**Our Ref: R/161/12/
Your Ref:**

Application for Planning Permission for Works or Extension to a Dwelling

Development Single storey rear extension, garage to side, boundary wall, garage conversion & balcony to front elevation
Location Conifers The Thatchway Rustington

WEST ELEVATION – STREET
(As Existing)

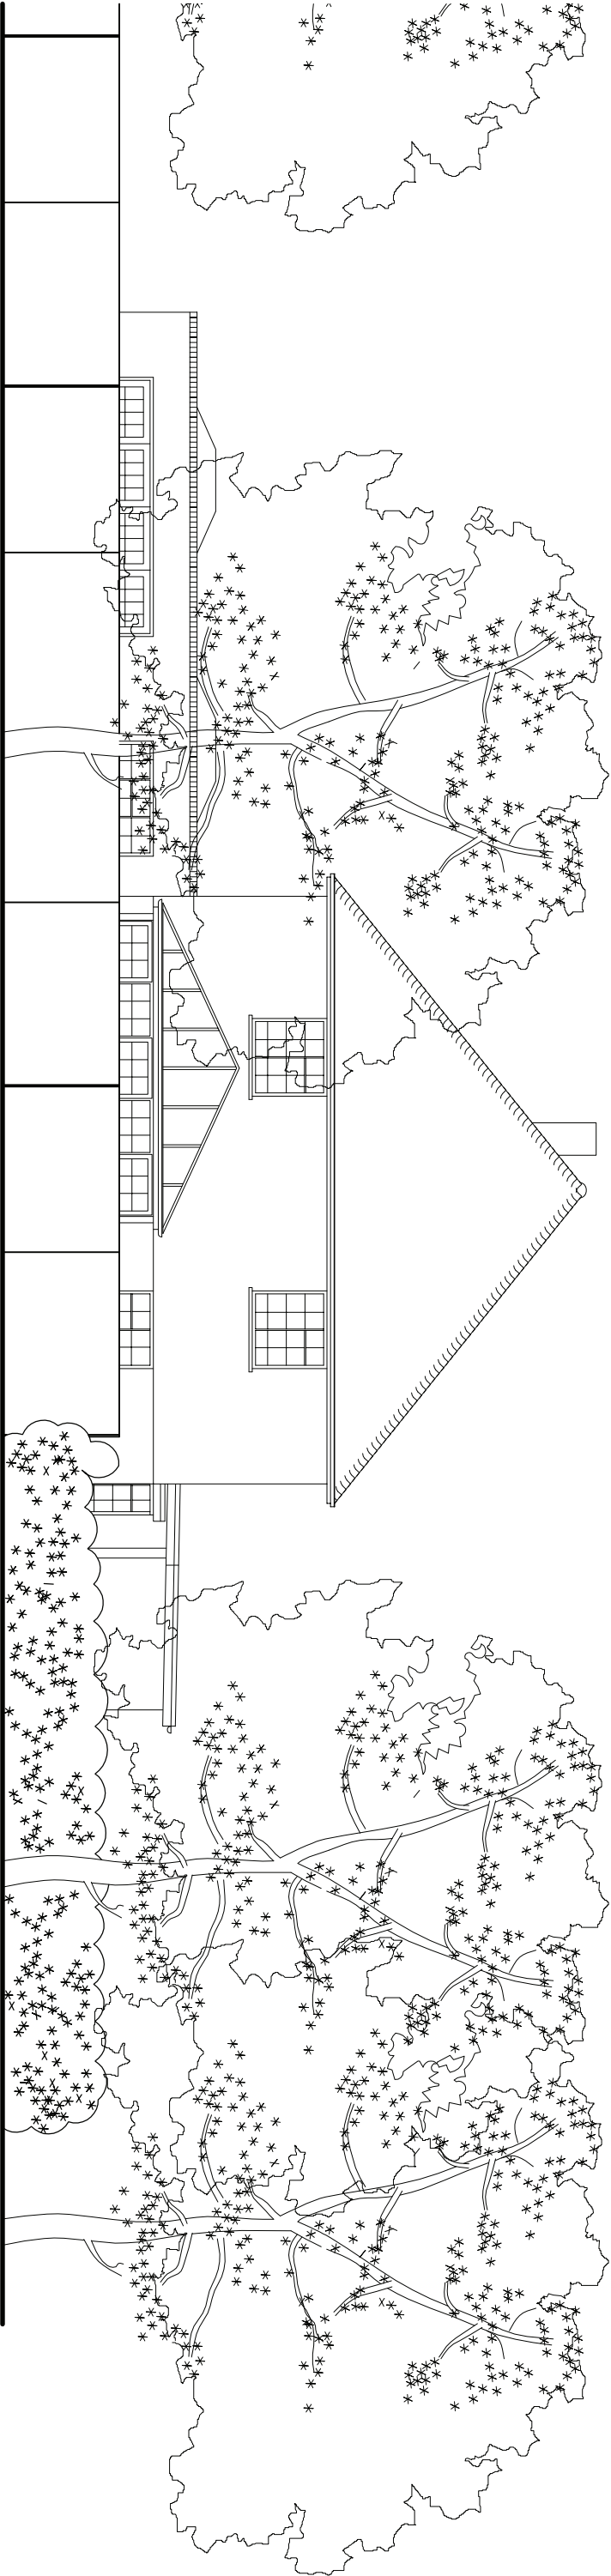
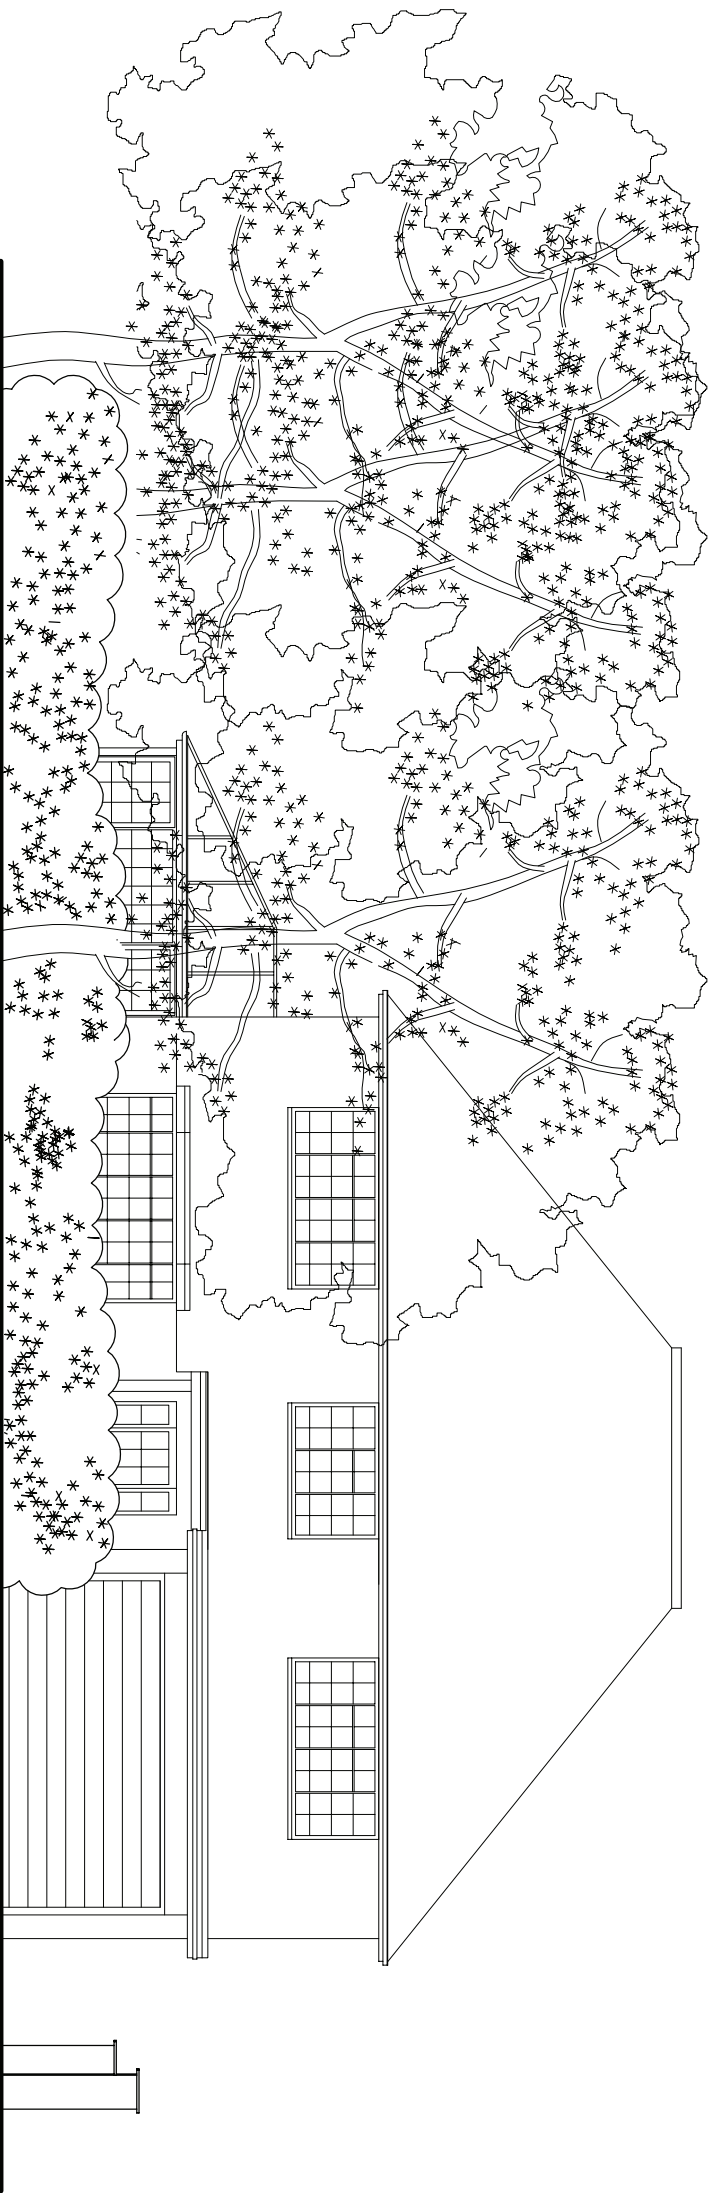
Please provide 1 electronic or 3 paper copies of existing west and south elevations of the boundary treatment.

SITE PLAN
Scale 1:500

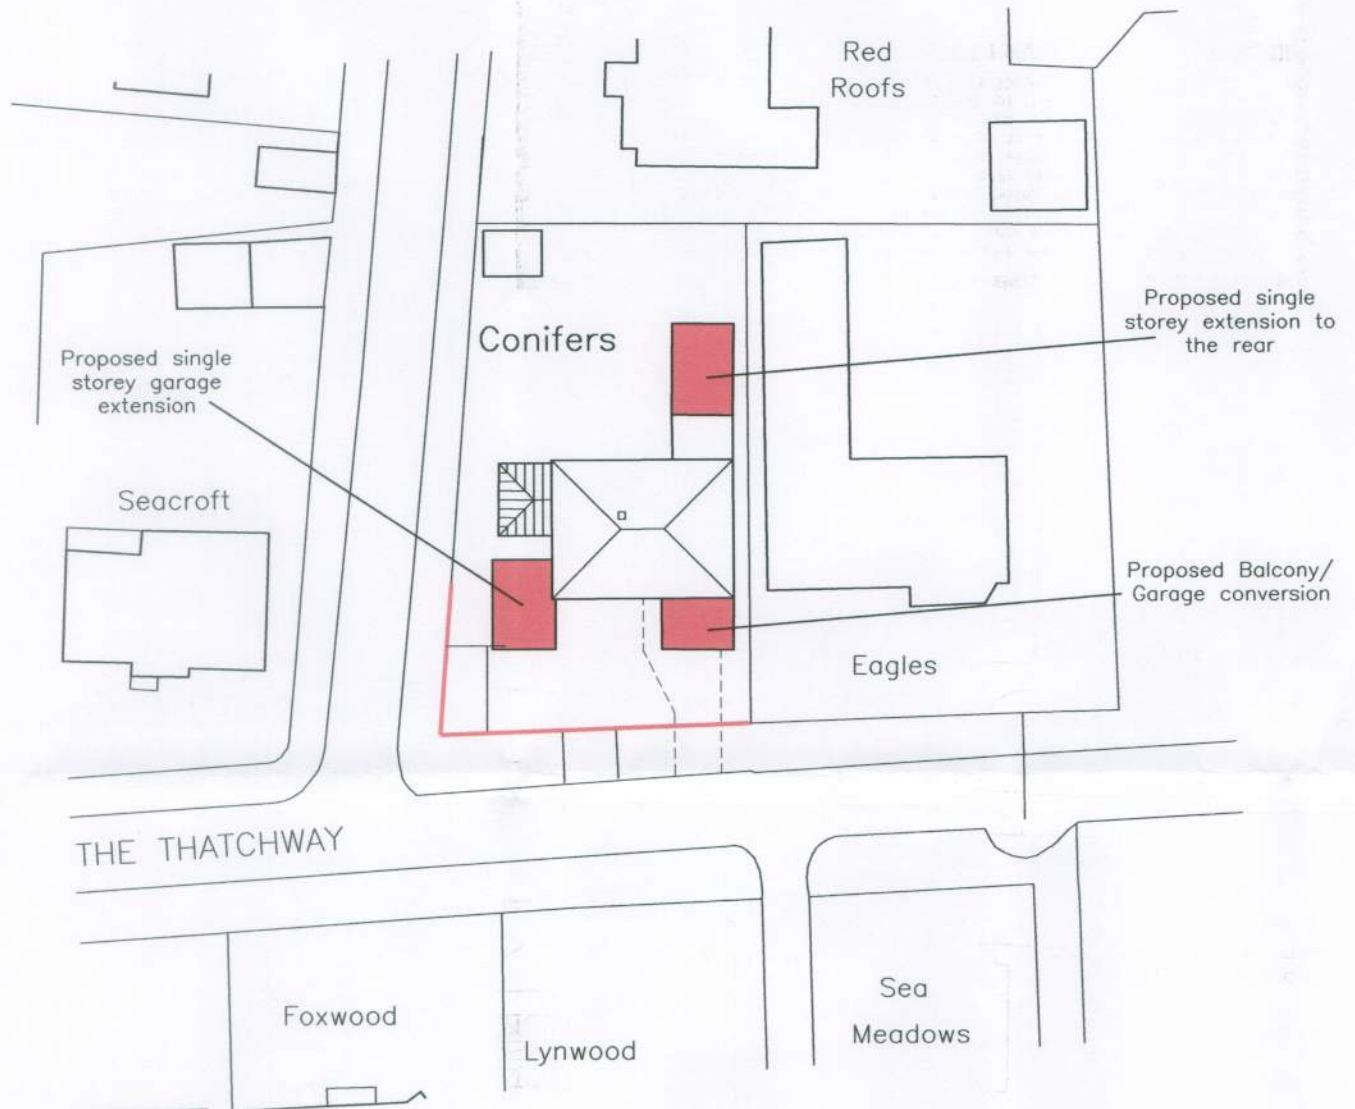
I require 1 electronic or 3 paper copies of a revised block/site plan showing the garage conversion, balcony and boundary wall clearly highlighted (to match the proposed garage and rear extension).
